Application Reference: LU/119/25/PL

Location: Lineside Way, Wick, Littlehampton, BN17 7EH

Proposal: Extension of industrial unit and installation of new palisade fencing gates to adjoin existing dropped kerb (resubmission following LU/303/24/PL). This application is in CIL Zone 4 (Zero Rated) as other development.

Below are the detailed responses to the consultations raised by the Arun District Council Engineer (ADC/SB) dated 22/10/2025, incorporating the amendments to the design and information of the Southern Water (SW) water authority.

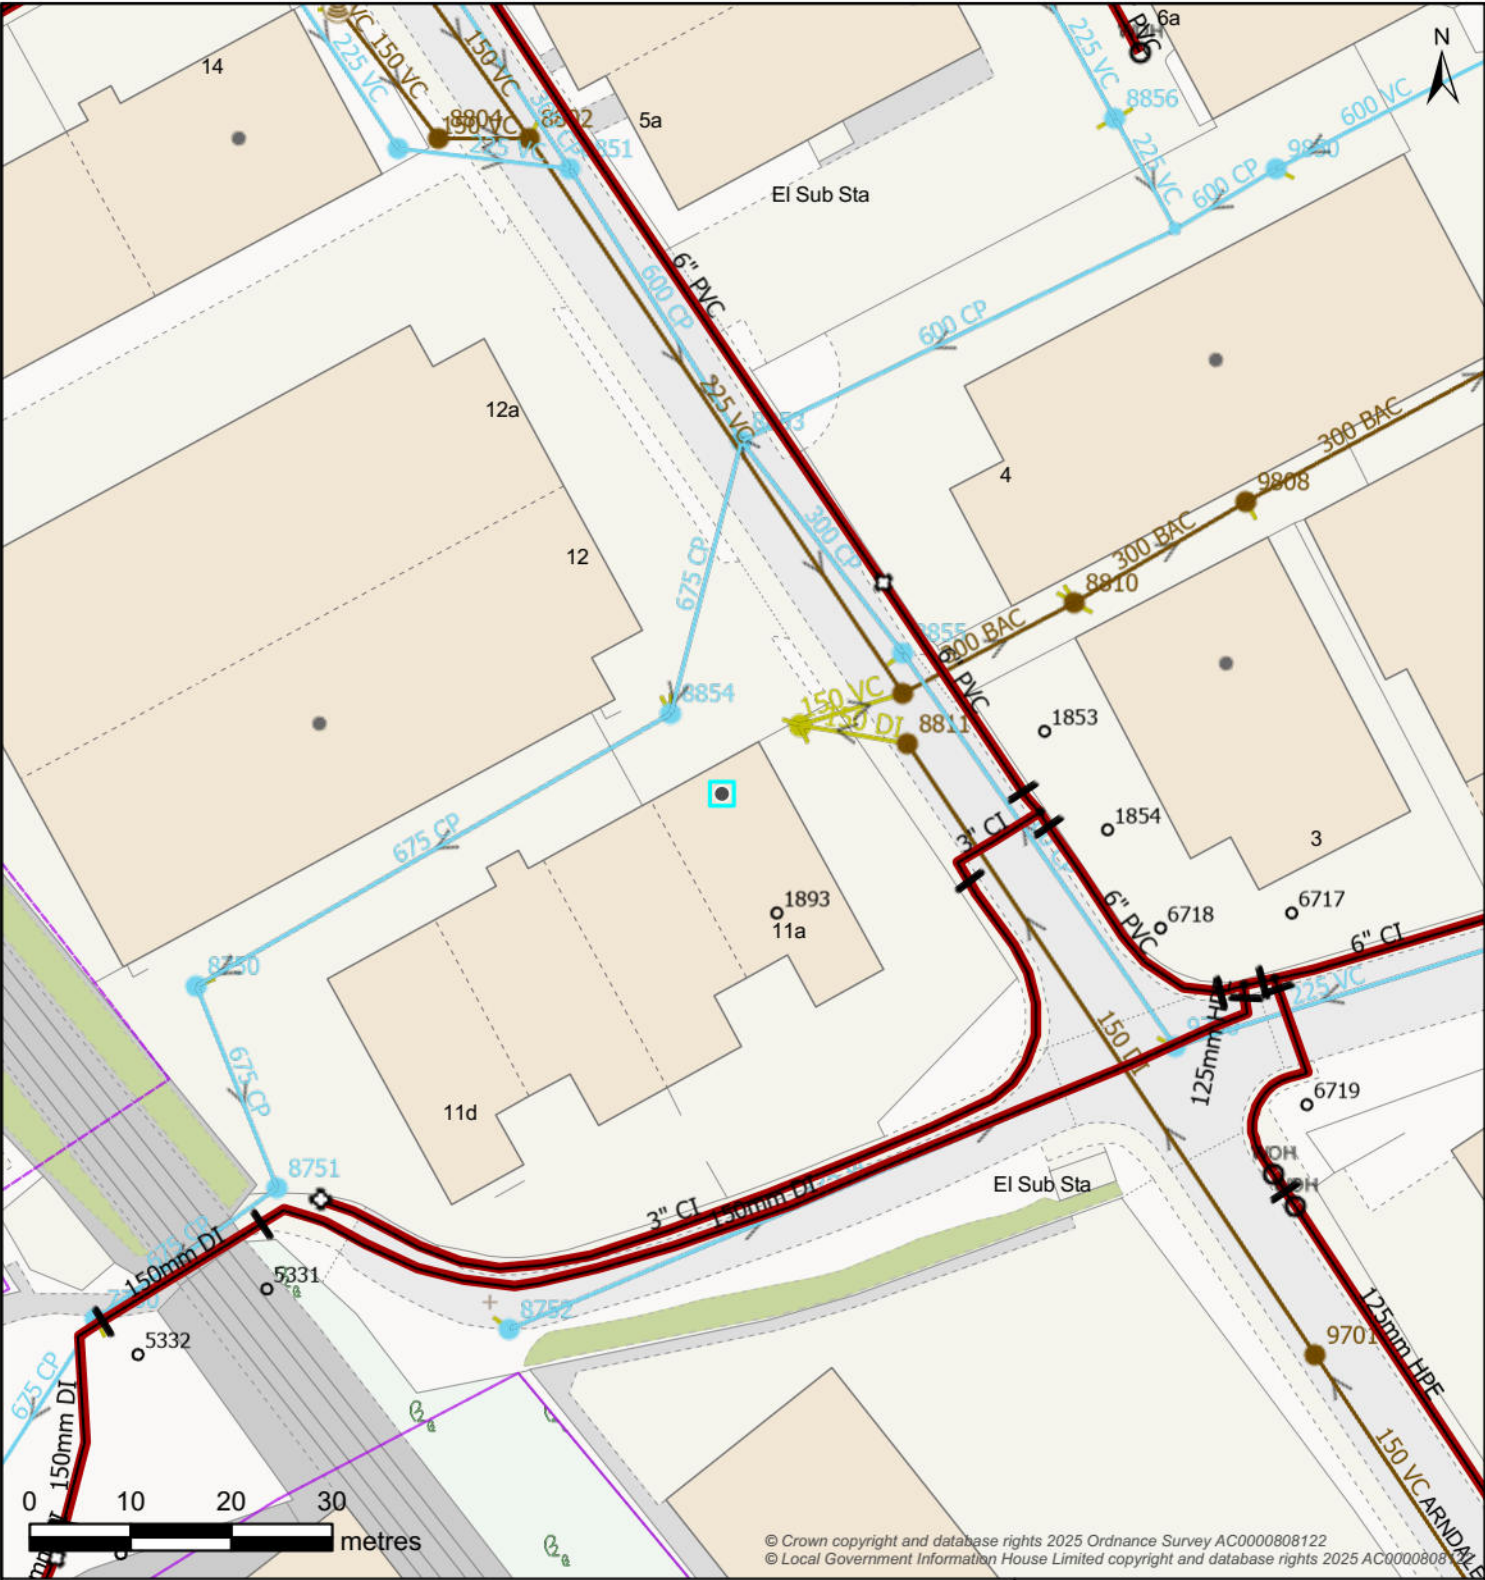
- 1.3. However, insufficient information has been submitted regarding the existing drainage arrangements of the site. The proposed extension is directly over the mapped public surface water sewer. It is unclear if Southern Water (SWS), the asset owner, have been consulted regarding the proposal. An easement to the sewer may need to be observed or the sewer diverted to the satisfaction of SWS. The sewer is a 675mm diameter pipe laid at relatively shallow depth. This means that it is likely to need an easement and that a diversion would be required. The scope for diversion is limited within the site as the proposed building footprint extends to the boundary at the southwest corner. Therefore, the diversion may need to be in third party land, yet adjacent to this site is the railway embankment. This may impact the deliverability of the proposed extension and its surface water drainage design. It has not therefore been demonstrated that a viable disposal location has been identified for this proposed extension and therefore I **object** to the application.

- 1.4. Even if the disposal point was changed to manhole 8752 (on the public sewer records as submitted by the applicant) the challenges associated with building over the existing sewer would remain. If planning permission is granted and the sewer network is damaged by the proposed extension, then this would impact flood risk upstream in the catchment.

Response: The destination point for surface water runoff is confirmed to be the Public Surface Water Sewer on Lineside Way. Southern Water has confirmed that there is adequate capacity in this network for the proposed flow rate of 0.7l/s. We recognize that the proposed extension overlaps with the 675mm diameter surface water pipe. Southern Water requires a clearance of 3.5m on each side of this culvert and does not normally allow building over a public culvert. The solution is to divert the public sewer line to avoid the extension area, bringing it to the left, surrounding the new structure. This diversion will be evaluated and agreed with Southern Water (SW). Application S106 will be submitted for sewer connection. Evidence of the agreements and implementation of the diversion will be provided to ensure compliance with regulations.

Drawing:
Proposed Drainage Strategy

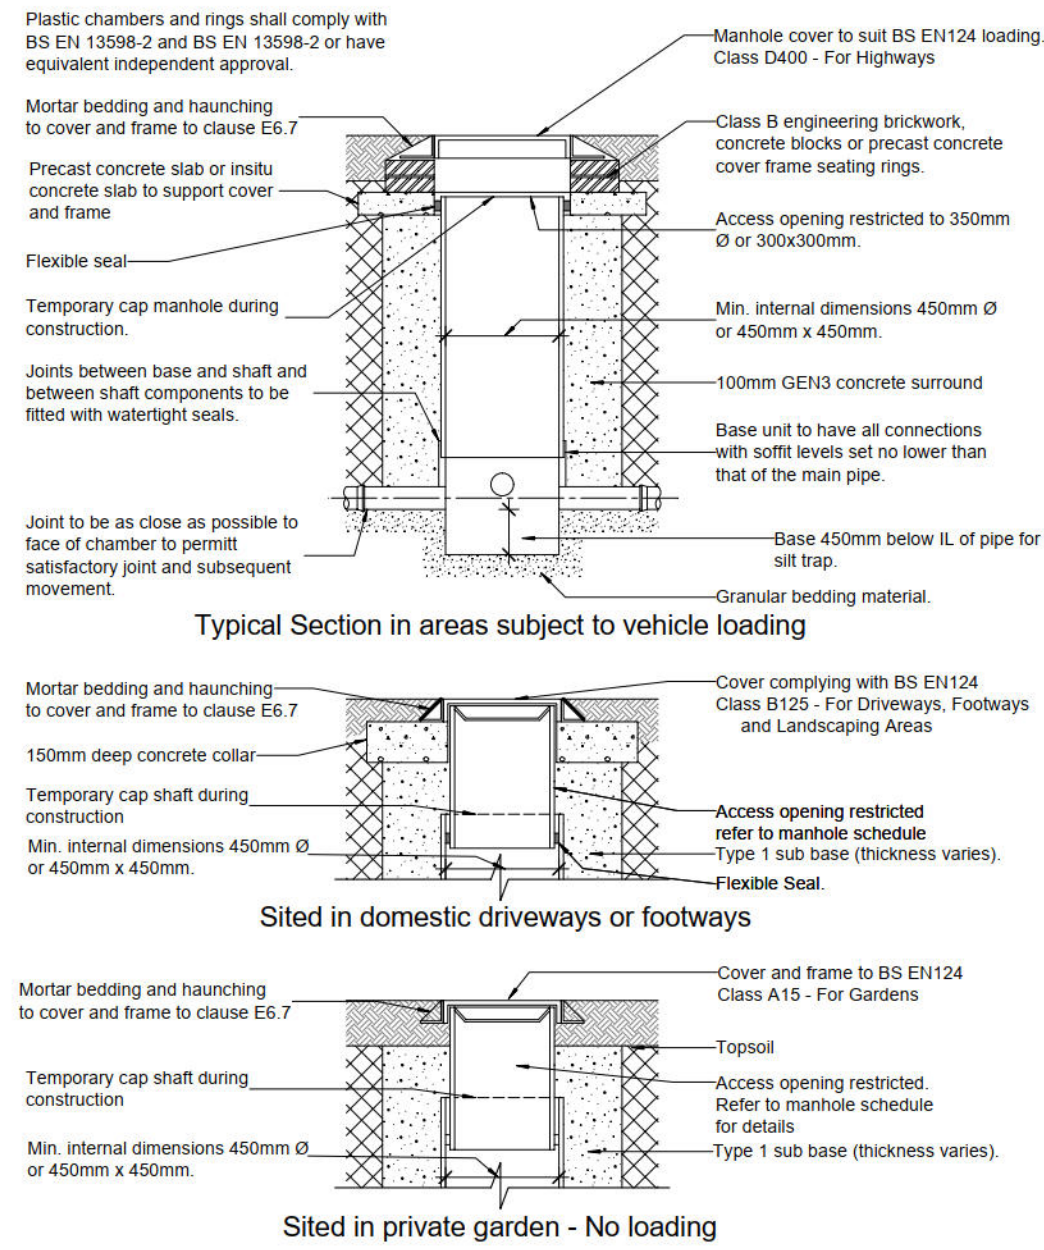
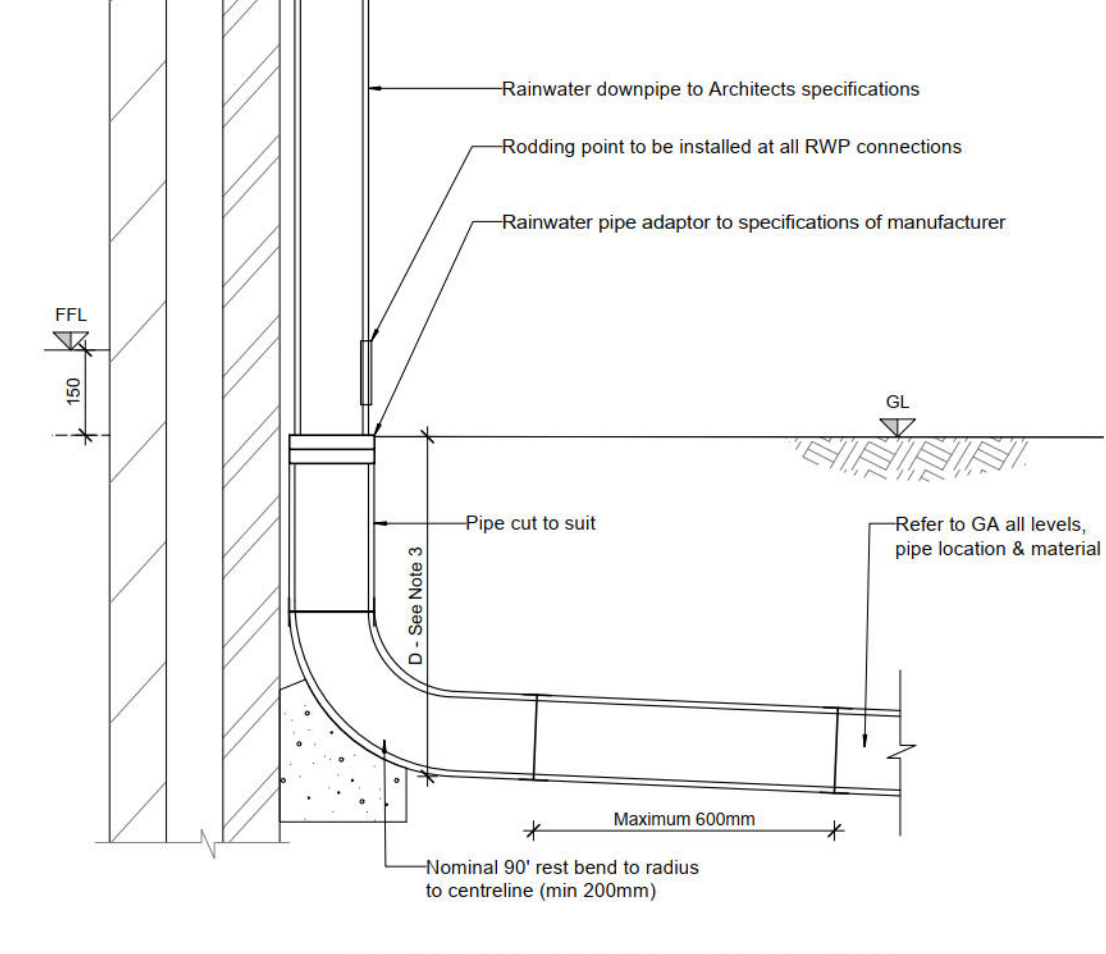
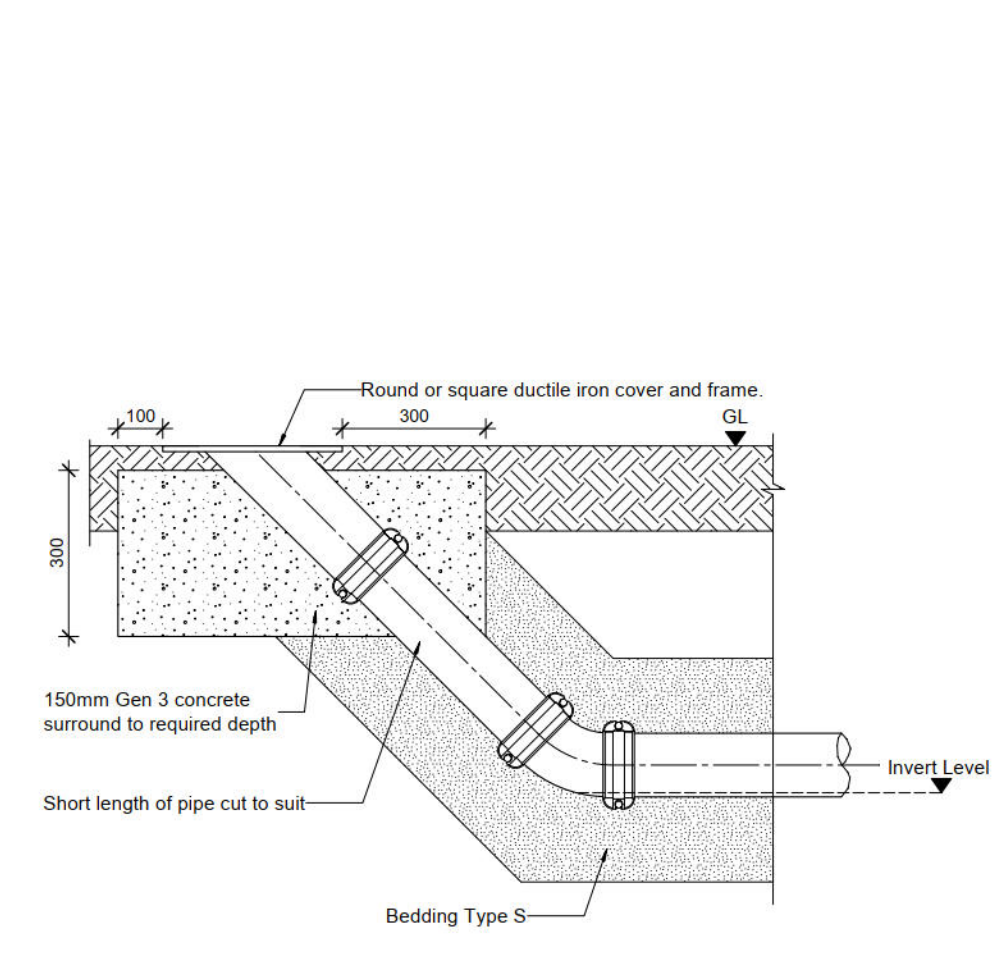
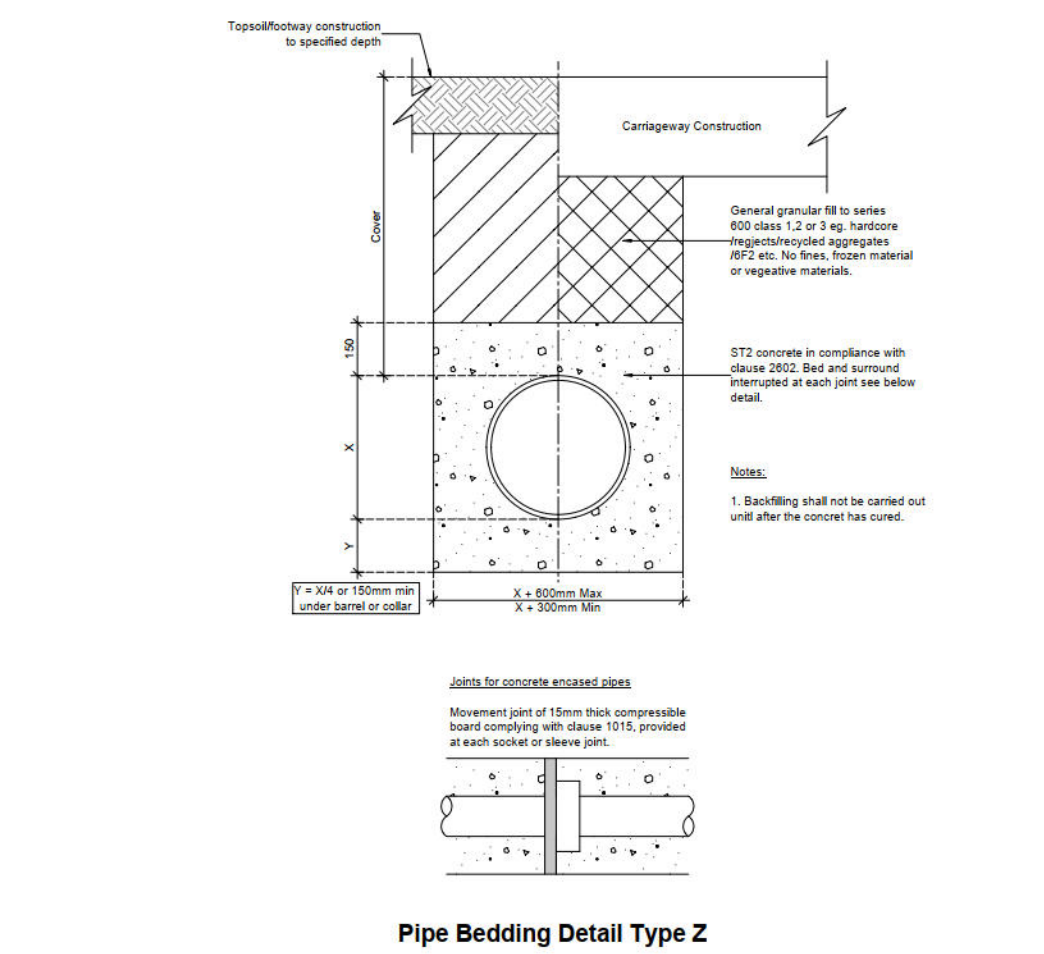
- 3.7. The design has been modelled with level inverts which does not reflect best practice (as opposed to level soffits).

Response: We have completely reviewed and updated the drainage modeling and design to address the deficiencies raised in Query 3, demonstrating the system's full functionality under extreme conditions and confirming that flood risk will not be increased. The calculation methodology has been updated from FSR to **FEH 2022** and the **45% Climate Change (CC)** factor has been applied for the 1 in 100-year event. The modeling has been corrected to use **Level Soffits** instead of *Level Inverts*, adhering to best engineering practices. The system will be designed as a **completely sealed closed circuit** to prevent surface water from entering the underground tank and the building, which includes the installation of a **non-return valve** at the point of surface water connection. The updated modeling confirms the discharge rate is maintained at **0.7l/s** and shows that while the tank node reaches a **SURCHARGED** status during the critical 100 year + 45% CC event, it **never reaches a state of FLOOD**, thus confirming sufficient storage capacity. Furthermore, the overflow water will be directed by the natural topography towards the **public roadway (Lineside Way)**, moving away from the building structure and outside the development area.
